Recommendation Report for Planning Permission for Works or Extension to a Dwelling

REF NO: AW/332/21/HH

LOCATION: 7 Raleigh Road
Aldwick
PO21 3NA

PROPOSAL: Loft conversion to form new 2nd floor with alterations to roof to form gable end & rear dormer projection.

sheet 2 of 3

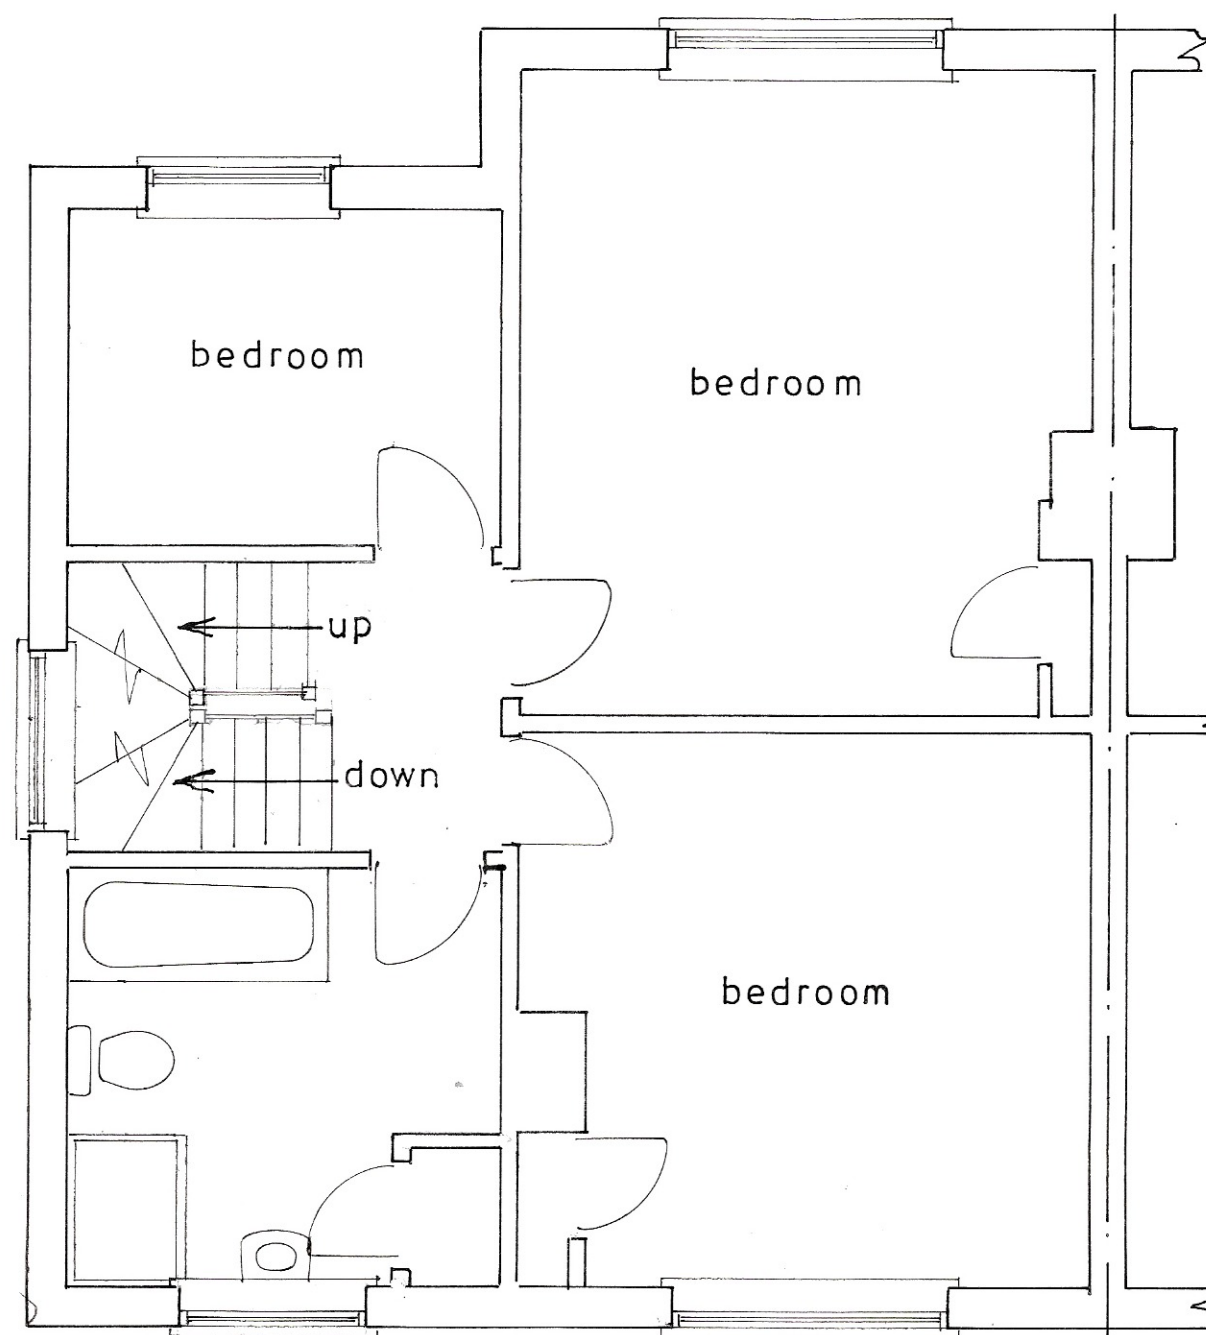
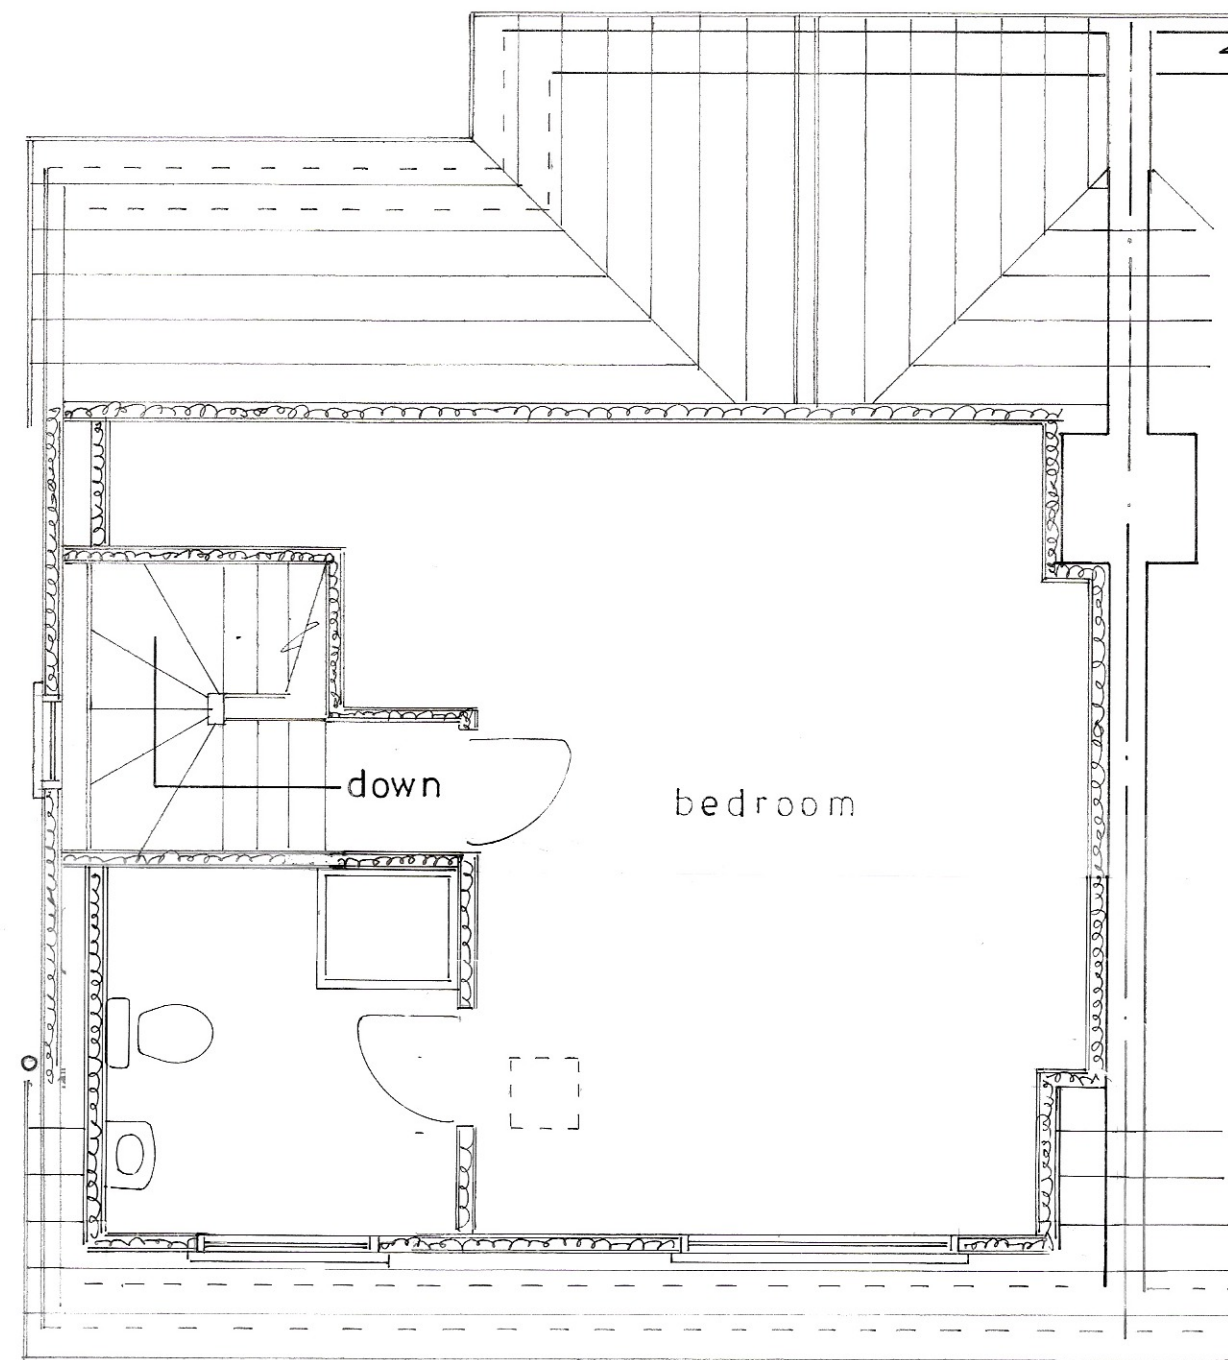
The roof has a hip to the front that will form a gable end. The gable end will measure approximately 3.74m wide x 3.48m high in line with existing roof ridge height. The loft conversion will form a new second floor containing a new bedroom and bathroom. There will be one new window to side (west).

Due to one new window to side (west) second floor there is increased risk to overlooking to number 9 however due to no direct windows to number 9's east side first floor there is no adverse harm caused.

sheet 1 of 3

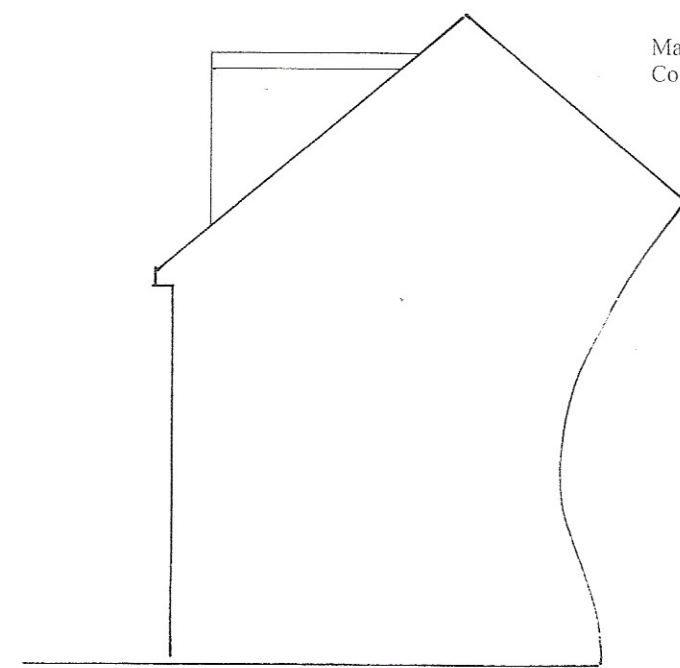
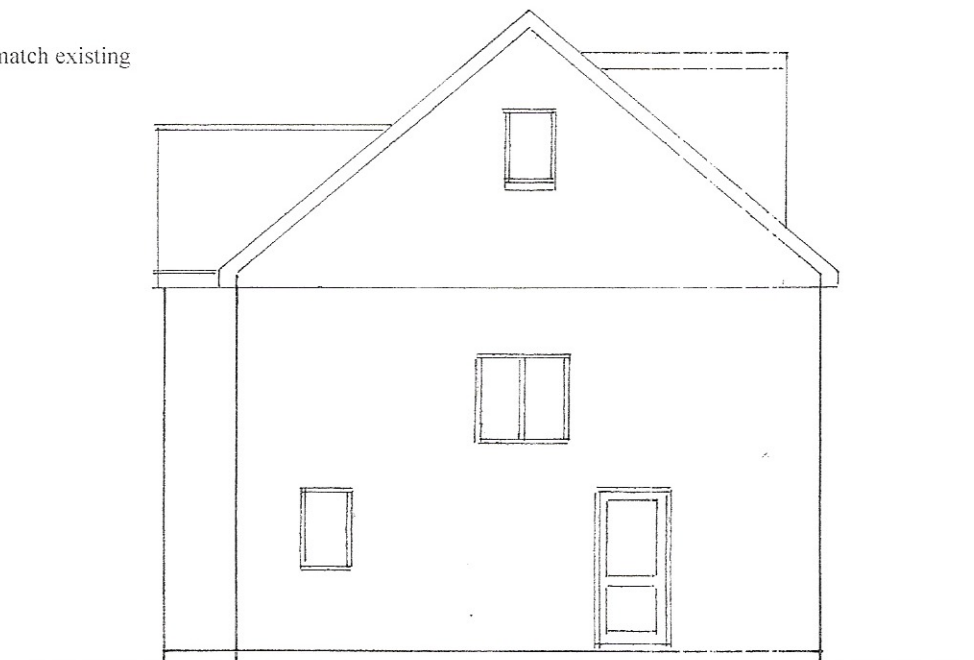
To the rear there will be a new flat roofed dormer containing two windows facing south. Due to being sited to rear it is less visible from street scene so will not adversely impact character of surrounding area. The dormer will measure approximately 6.51m wide x 2.41m high x 2.76m deep.

The materials consist of roof tiles to match existing, Marley Cedral cement boarding cladding to dormer colour Violet Blue Code: C52 and UPVC windows.

Due to the new gable end to side (west) roof plane, it will affect neighbouring amenity to number 9 Rayleigh Road to west. However due to around 3.91m retained to west side boundary the impact is reduced and due to location of number 9's garage there is no harm caused.

Due to the dormer containing two new widows to rear (south) there is increased overlooking impact to neighbouring property to south however a large gap of around 19.11m retained to rear (south) boundary there is no adverse impact to overlooking to neighbouring properties to south.
